TRAFFIC IMPACT ASSESSMENT (TIA)

**Proposed Waste Management facility
2-4 Hale Street, Botany**

Reference: 23.464r01v13
Date: March 2025

2.1 DPHI RFI

### Swept Path Analysis

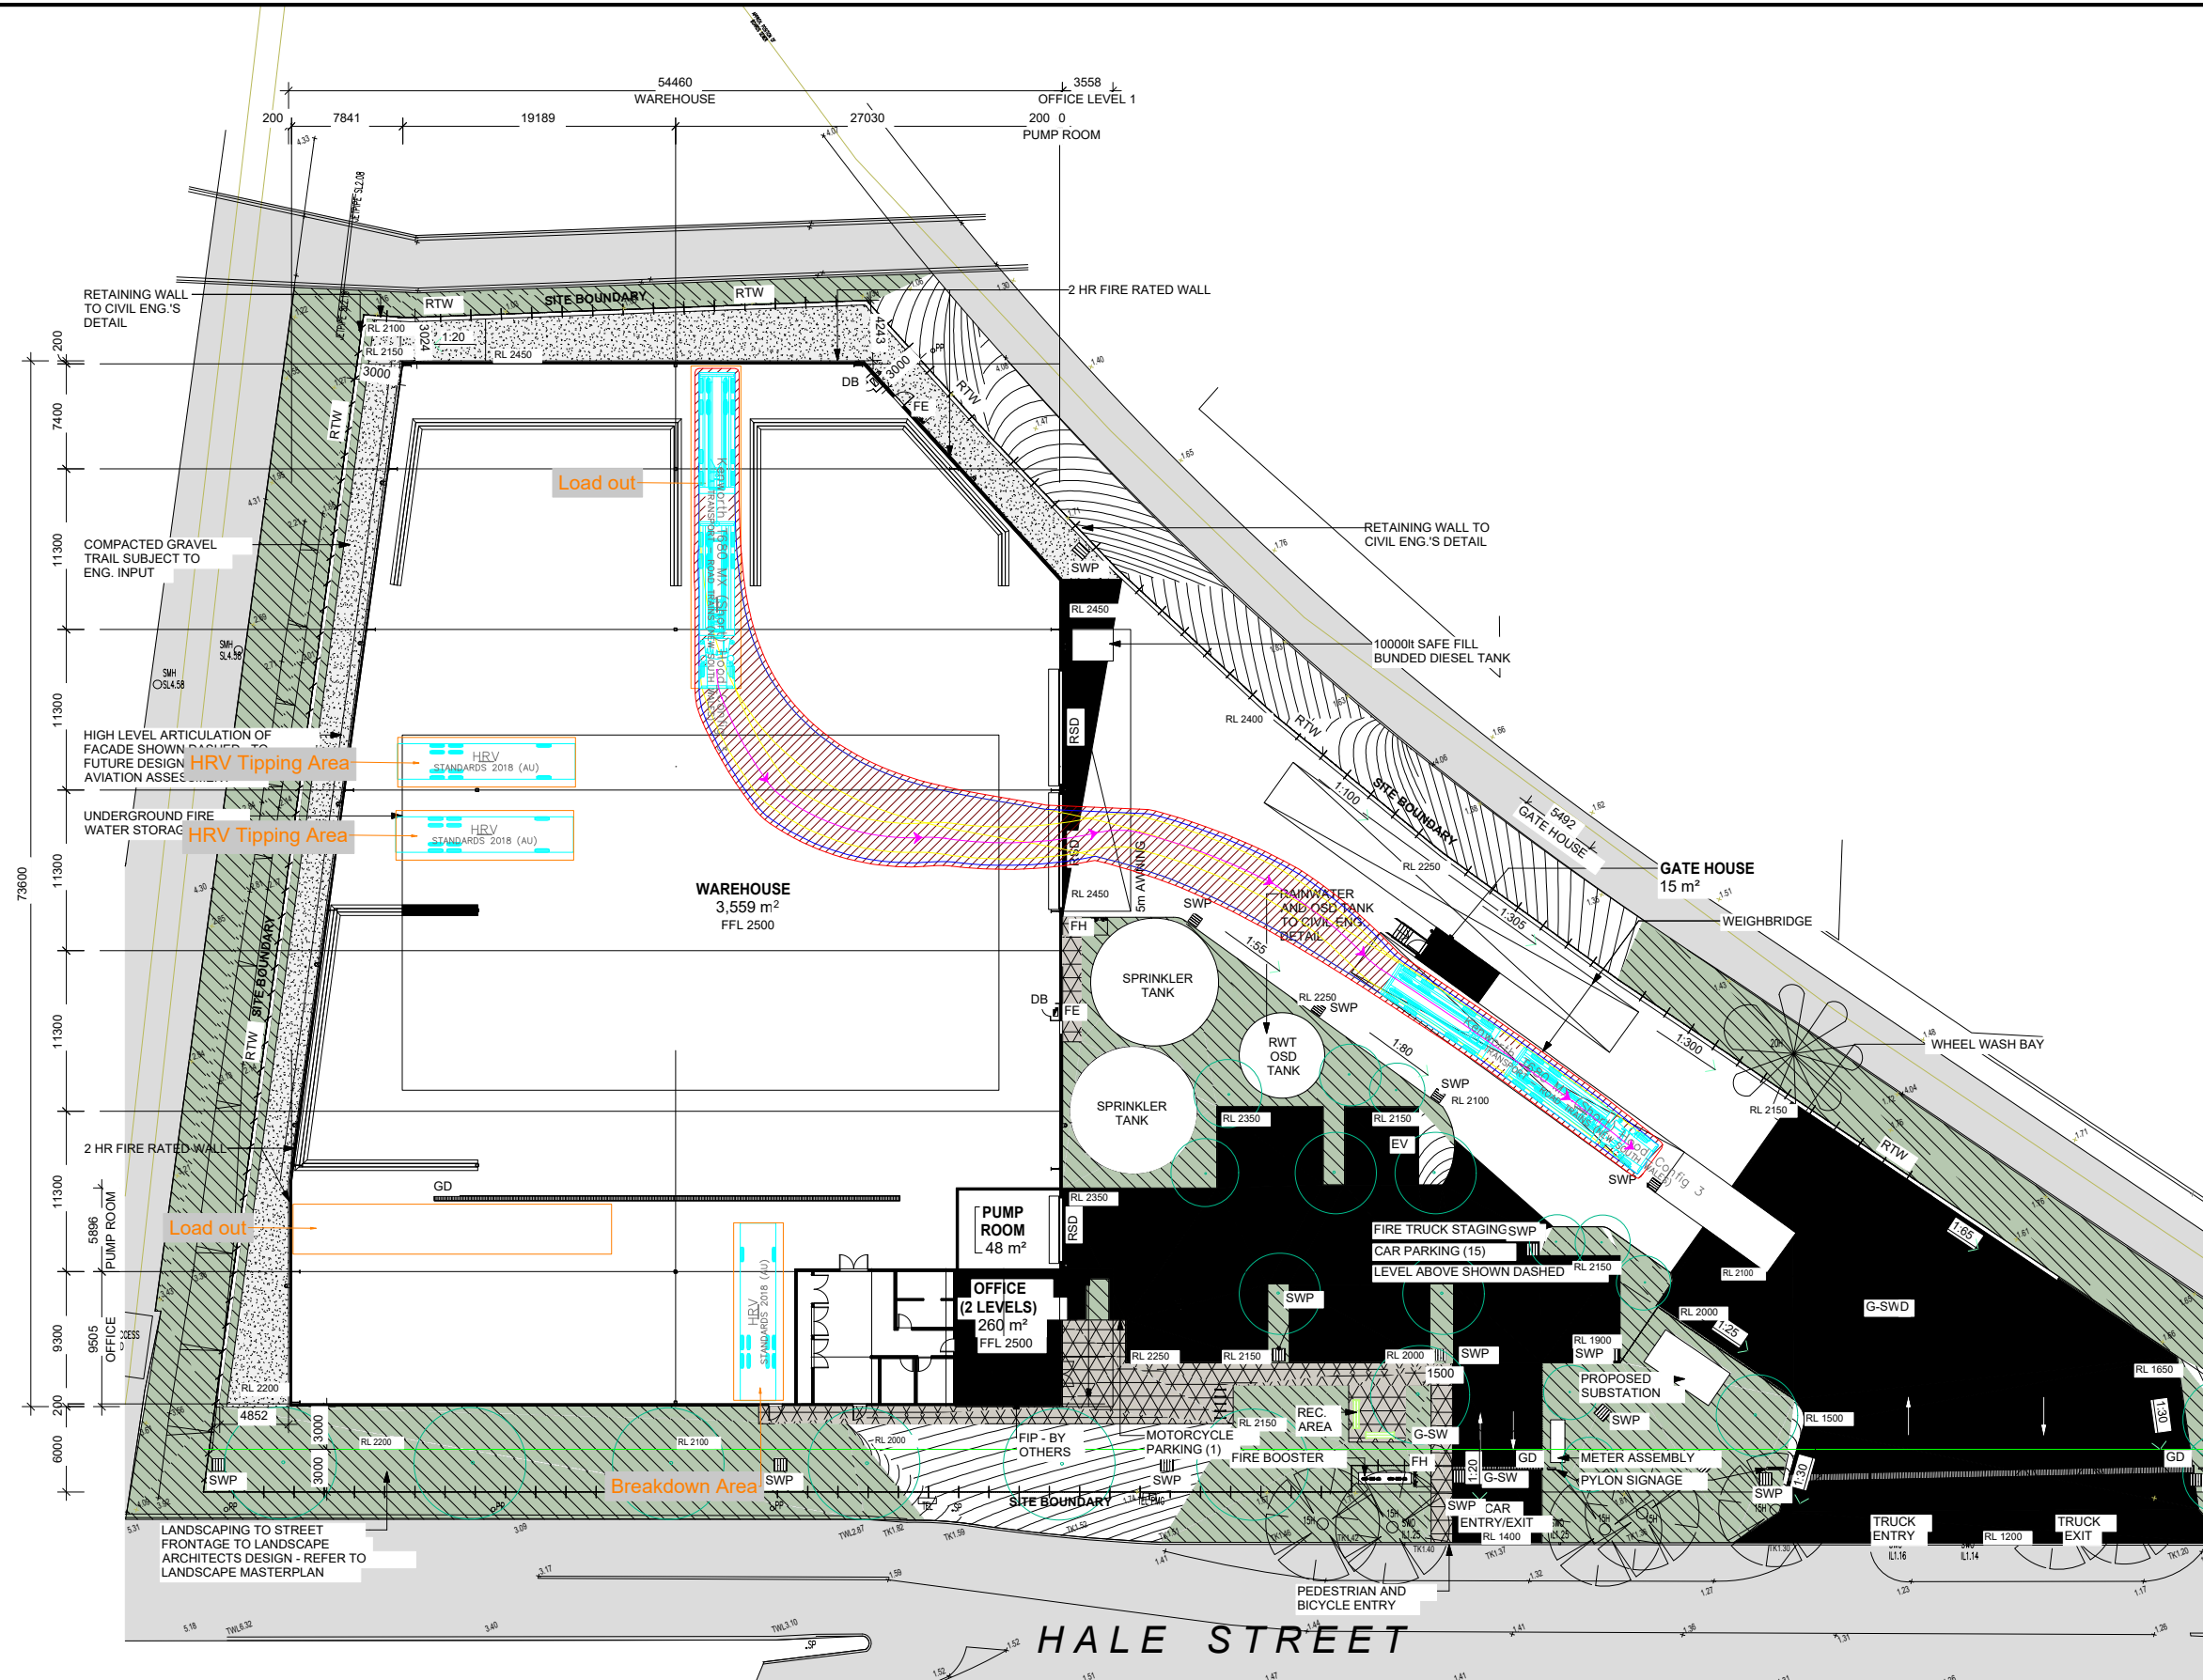
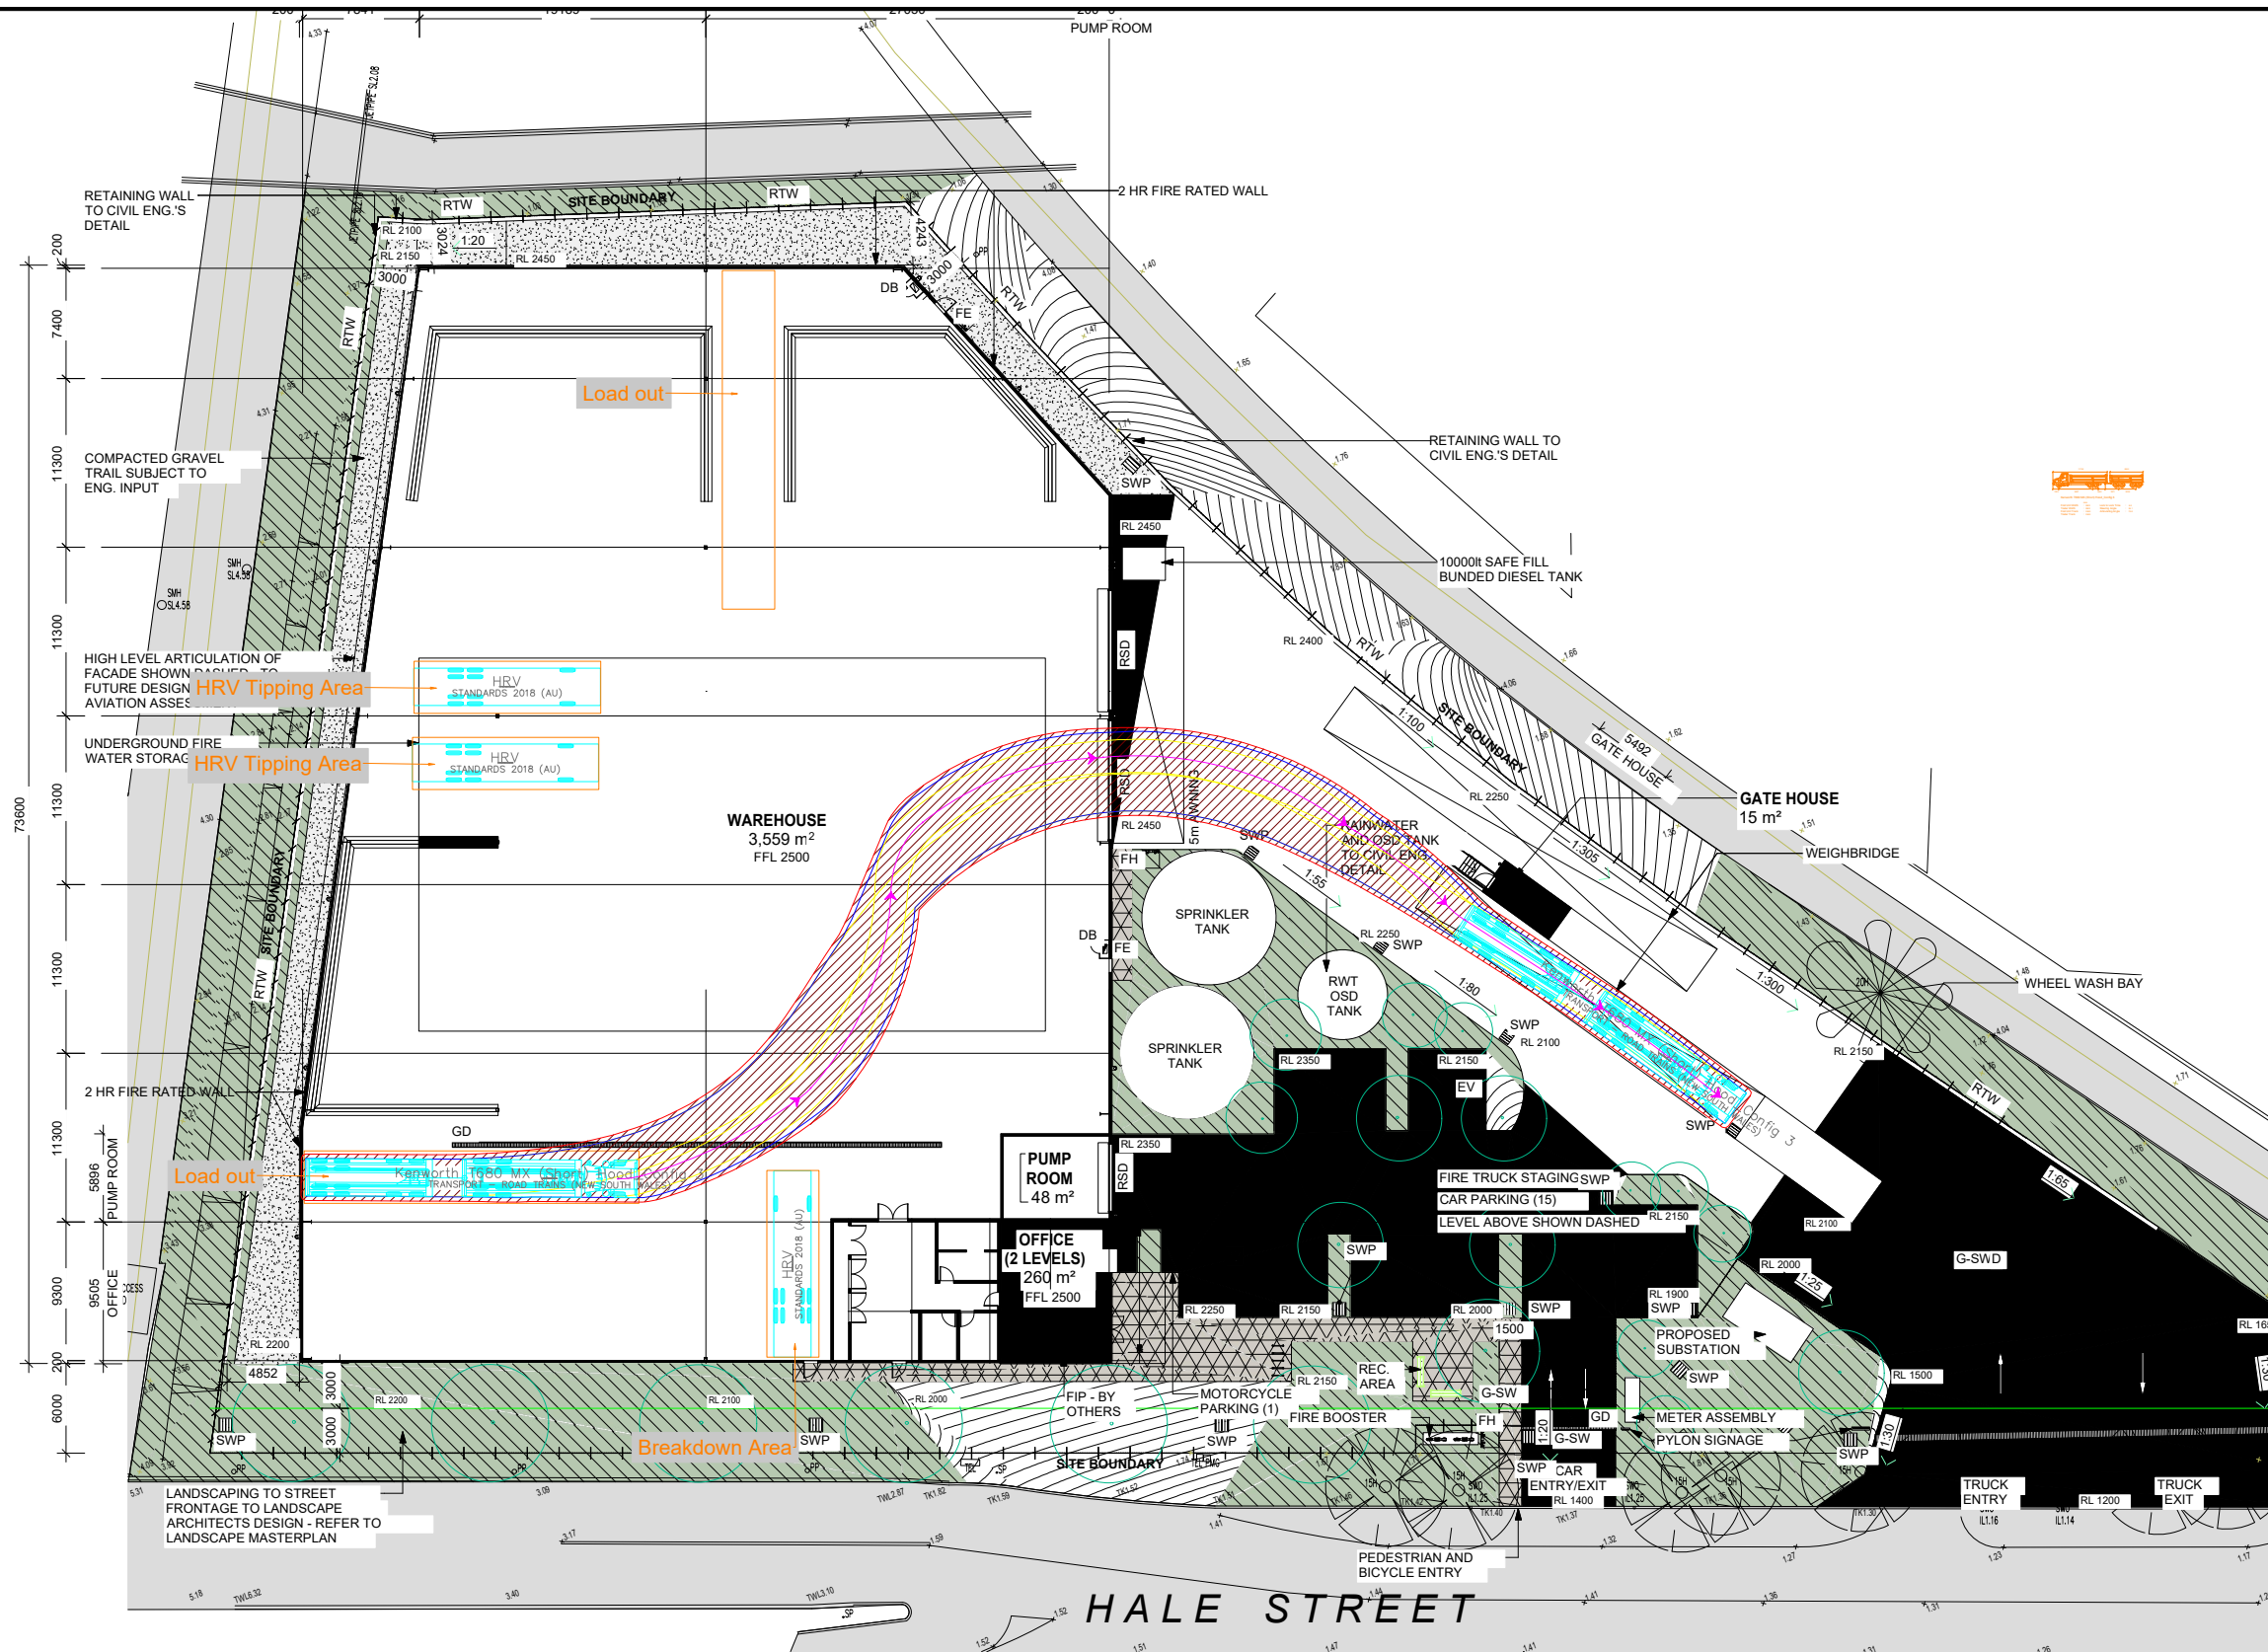
<u>Swept Path Analysis</u> The swept path analysis for the site access driveway provided at Appendix D of the TIA is unclear and indicates there may be conflict between two B-doubles travelling eastbound and westbound on Hale Street. Recommendation: Revised swept path analyses are required for 20 metre articulated vehicles and B-doubles accessing the site that clearly demonstrates the centreline of Hale Street will not be crossed and there will be no conflict with on-street parking. All line marking on Hale Street must be clearly marked.	Swept path analysis have been updated with recent Nearmap aerial georeferenced in the background clearly demonstrating 26m B-double vehicles will be able to ingress and egress the site satisfactorily in accordance with AS 2890.2 (2018).
<u>Daily Heavy Vehicle (HV) Movements</u> Section 6.10: Truck Frequencies of the TIA outlines the anticipated truck volumes for the development. It is not clear how these vehicle numbers have been determined. Bayside Council has also raised several queries regarding the traffic generation analysis. Recommendation: Additional information is required to justify the predicted truck volumes, including the breakdown of vehicle types.	TIA has been updated to provide detailed calculations on how the anticipated heavy vehicle trip generation associated with the proposed development has been estimated including a breakdown of the vehicle types, refer to Section 9.

Concerns are raised regarding the swept paths of 20m long AV and 26m B-Double conflicting with on-street parking on the southern side of Hale Street. The appendix D swept paths shall be revised with that southern on-street parking shown as minimum 2.4m wide from face of kerb. Swept paths can be undertaken on the assumption that parking on the northern side will be removed. Truck movements including 300mm clearance are not to impact on-street parking.	• Swept path analysis have been updated with recent Nearmap aerial georeferenced in the background clearly demonstrating 26m B-double vehicles will be able to ingress and egress the site satisfactorily in accordance with AS 2890.2 (2018).

The appendix D swept path analysis details an unrealistic kink in the truck wheel movement near the car entry/exit. See figure below.	All swept path analysis has been undertaken using the latest version of the industry leading software AutoTURN Pro, we can provide animated swept paths in a video file or live demonstration to Council upon request to prove our professional integrity.
The swept path analysis shall be revised to better depict all line marking on Hale Street. Vehicles shall not cross over the road centreline.	Swept path analysis have been updated with recent Nearmap aerial georeferenced in the background clearly demonstrating 26m B-double vehicles will be able to ingress and egress the site satisfactorily in accordance with AS 2890.2 (2018).
The parking rate derived in section 7 of the traffic report is insufficient for this site. 1 car parking space shall be provided for each staff member in addition to the 4 visitor spaces. Additionally, given the swept paths and the two driveways proposed, the on- street parking on the northern side of Hale Street is effectively entirely removed by this development. The loss of public parking needs to be supplemented by the development.	- The proposed development has been amended to provide a minimum of one (1) car parking space per FTE staff in addition to the four (4) visitor spaces in accordance with Council's request. - It is unclear how on-street parking can be supplemented by a private development that is not open to the public notwithstanding the security and legal challenges if this was permitted to occur. - Refer to Section 8.6 of this report.
